**RE: Baylor Drive Property
2635 Baylor Dr. SE
Grading and Drainage Plan
Engineer's Stamp Date: 08/07/19
Hydrology File: M16D044**

Based upon the information provided in your submittal received 08/07/2019, the Grading & Drainage Plan is not approved for Building Permit and for action by the DRB on Site Plan for Building Permit. The following comments need to be addressed for approval of the above referenced project:

GR-1

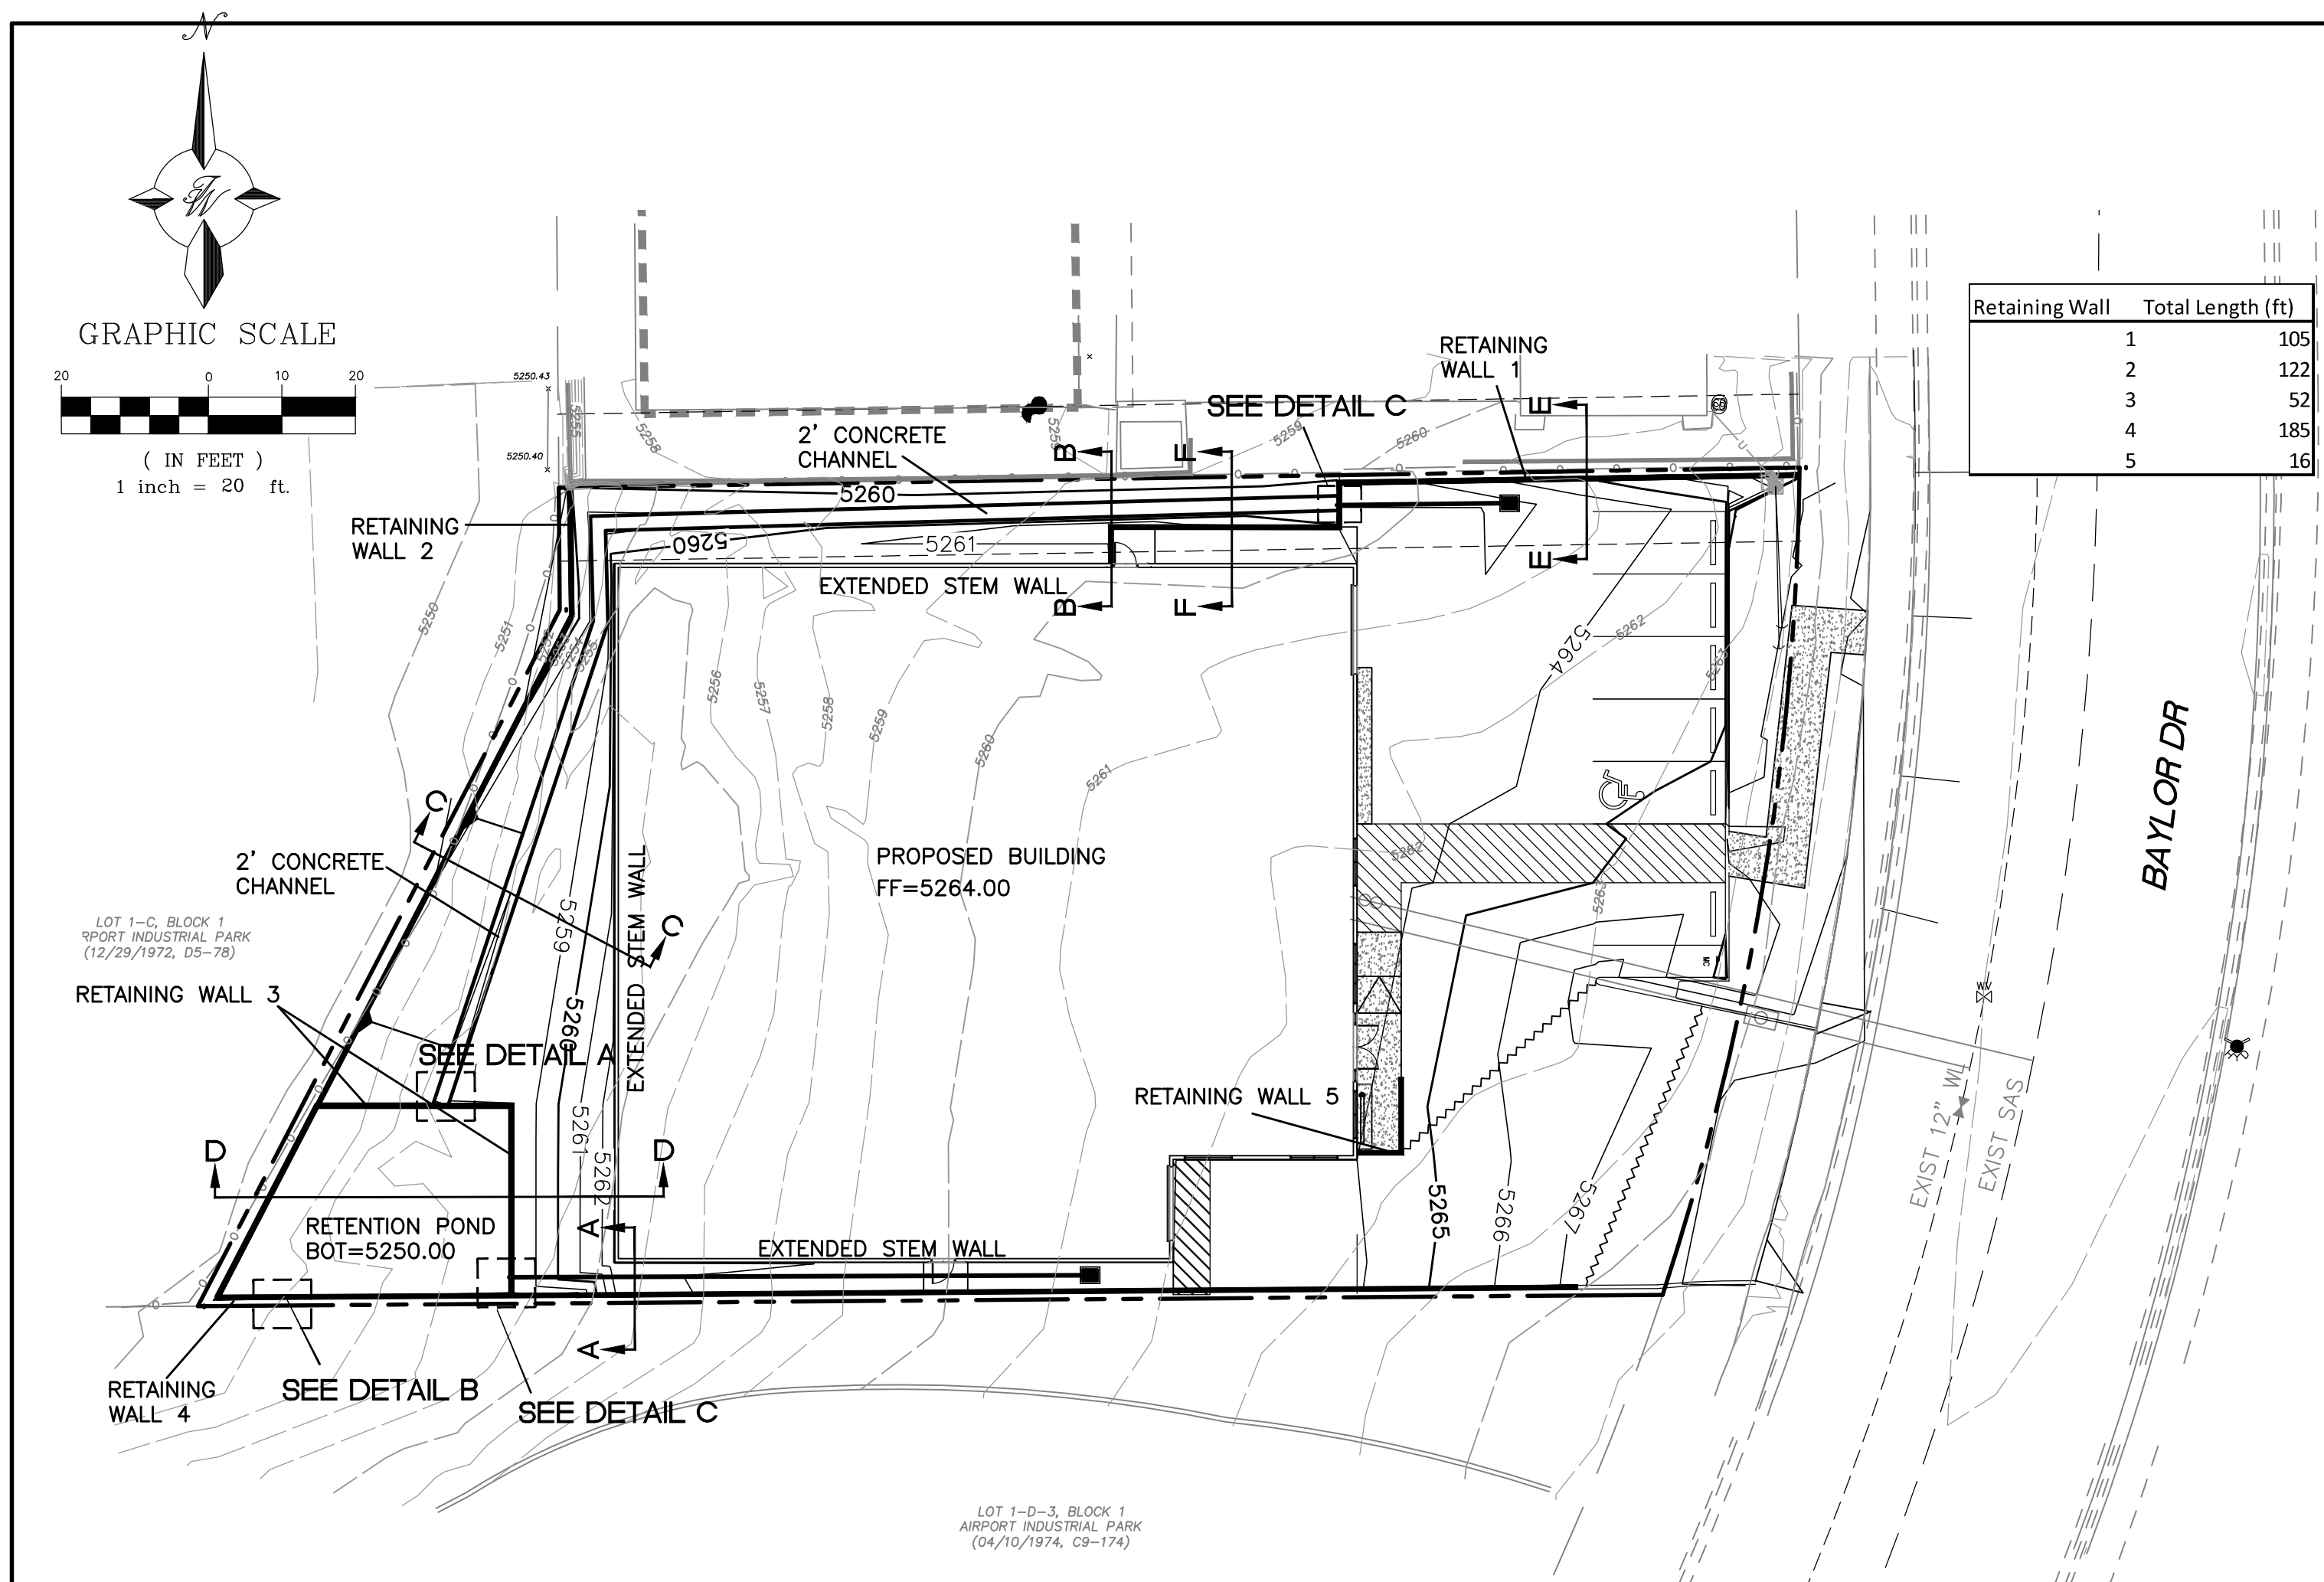
1. Provide the existing and/or proposed grades on both sides of the proposed retaining wall.
2. Provide sections through all external boundaries showing proposed retaining walls, garden walls, property/ROW lines, existing and proposed grades. In accordance with DPM Ch.22, section 5 part B, grading and wall construction near the property line may not endanger adjacent property or constrain its use.

4. Please provide a cross section of the proposed retention pond showing dimensions, the bottom elevation, the top of wall, and the water surface elevation of the 100 year 10 day volume.

5. Please provide a detail of the proposed 2 ft concrete channel entering the walled retention pond.
6. Please fix several overlapping text and missed placed text.
